KITTTITAS COUNTY COMMUNITY DEVELOPMENT SERVICES

Subject: Shoreline Exemption Permit (SX-20-00002) - Request for Additional Information

SITE PLAN

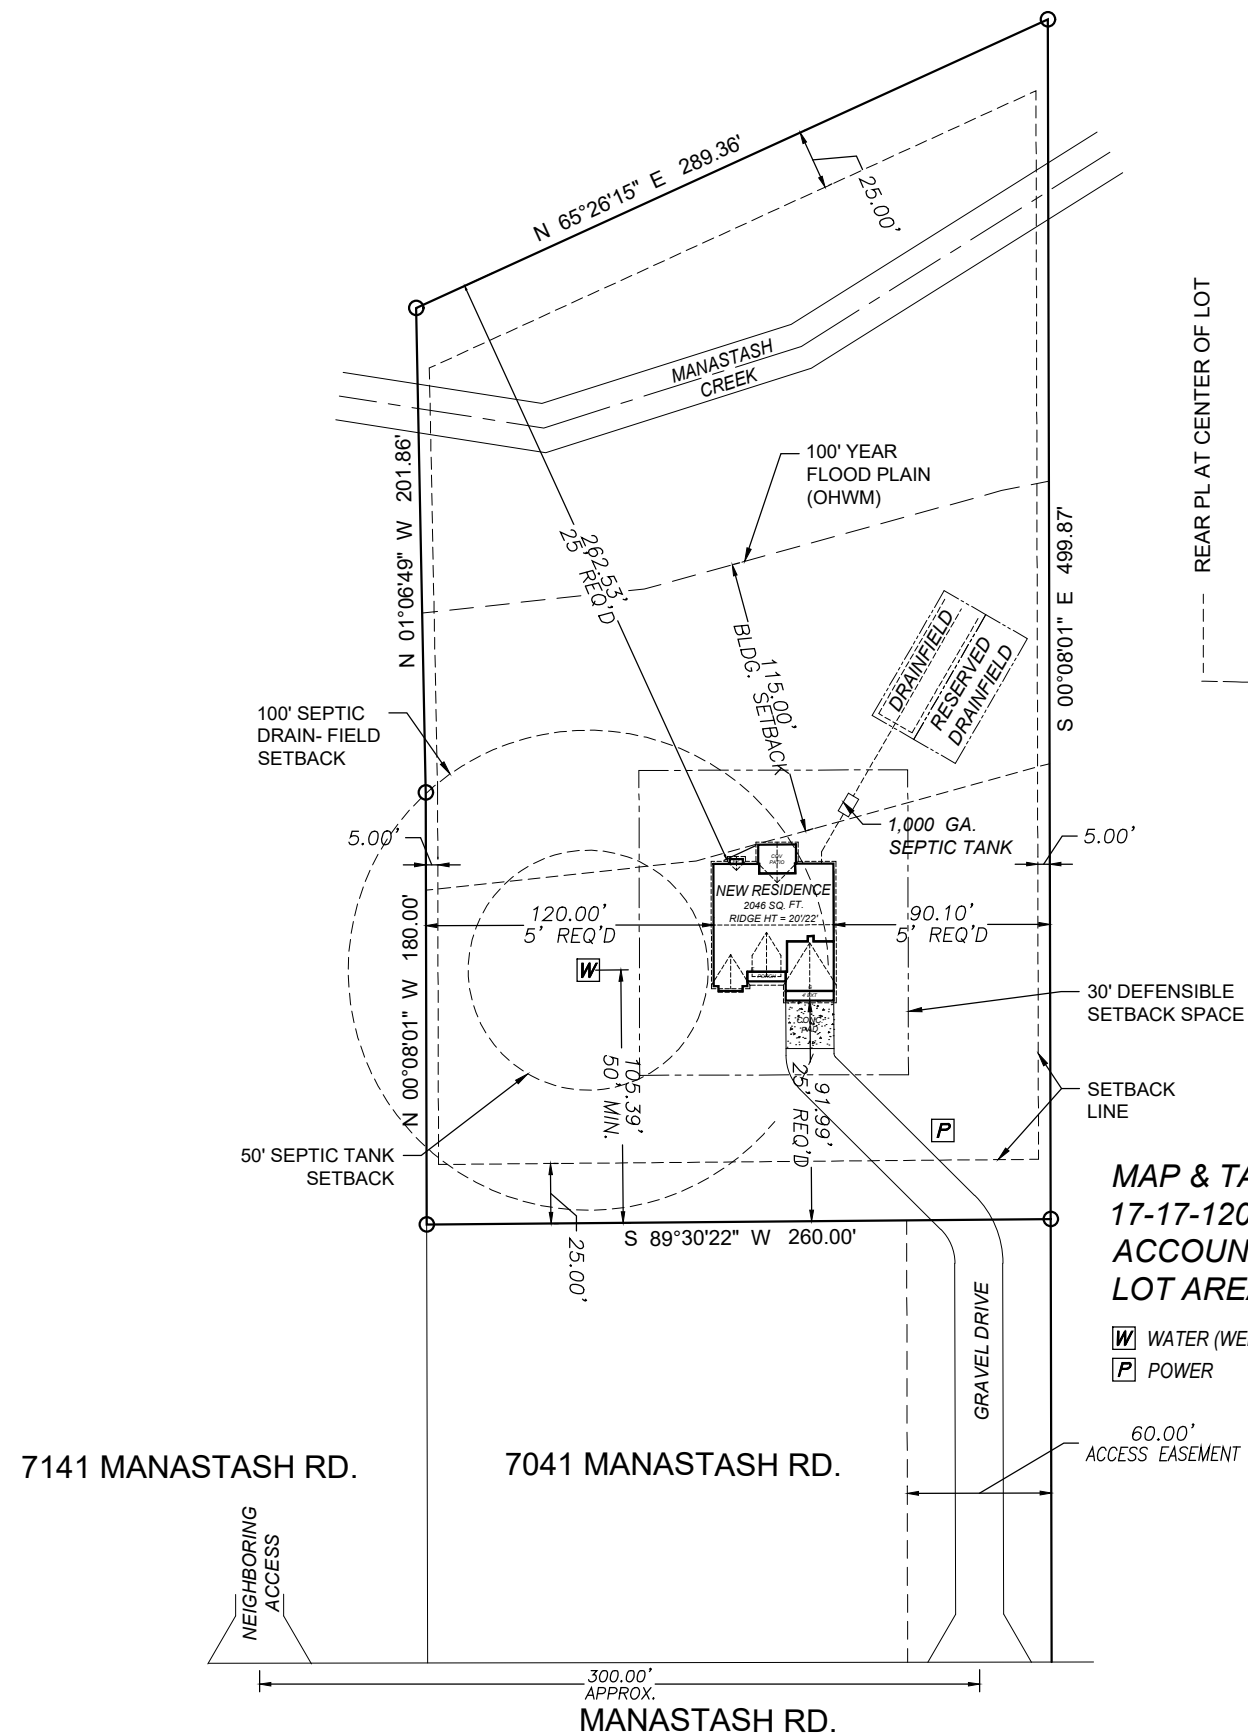
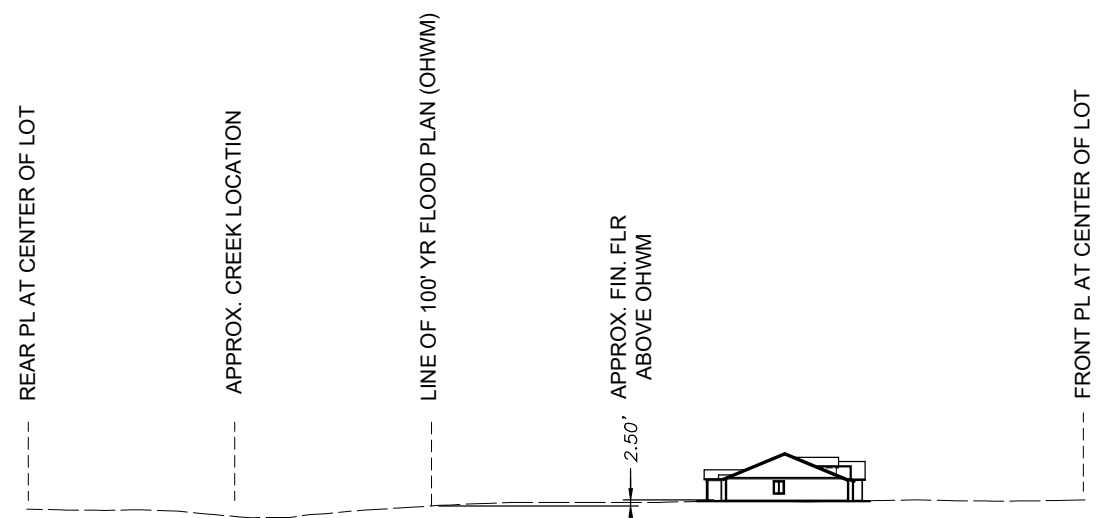
The updated site plan shows the drainfield located within the 115' buffer from the OHWM. A drainfield is considered a structure as defined in Kittitas County Code 17B.02.490: "Structure" means a permanent or temporary edifice or building, or any piece of work artificially built or composed of parts joined together in some definite manner, whether installed on, above, or below the surface of the ground or water, except for vessels. ([Ord. 2016-006](#), 2016).

1. An updated site plan with the drainfield being located outside the OHWM setback of 115 feet.
2. Staff from Public Works and Community Development Services are requesting a meeting to discuss your project in full, regarding the site plan, OHWM, setbacks and flooding risks.
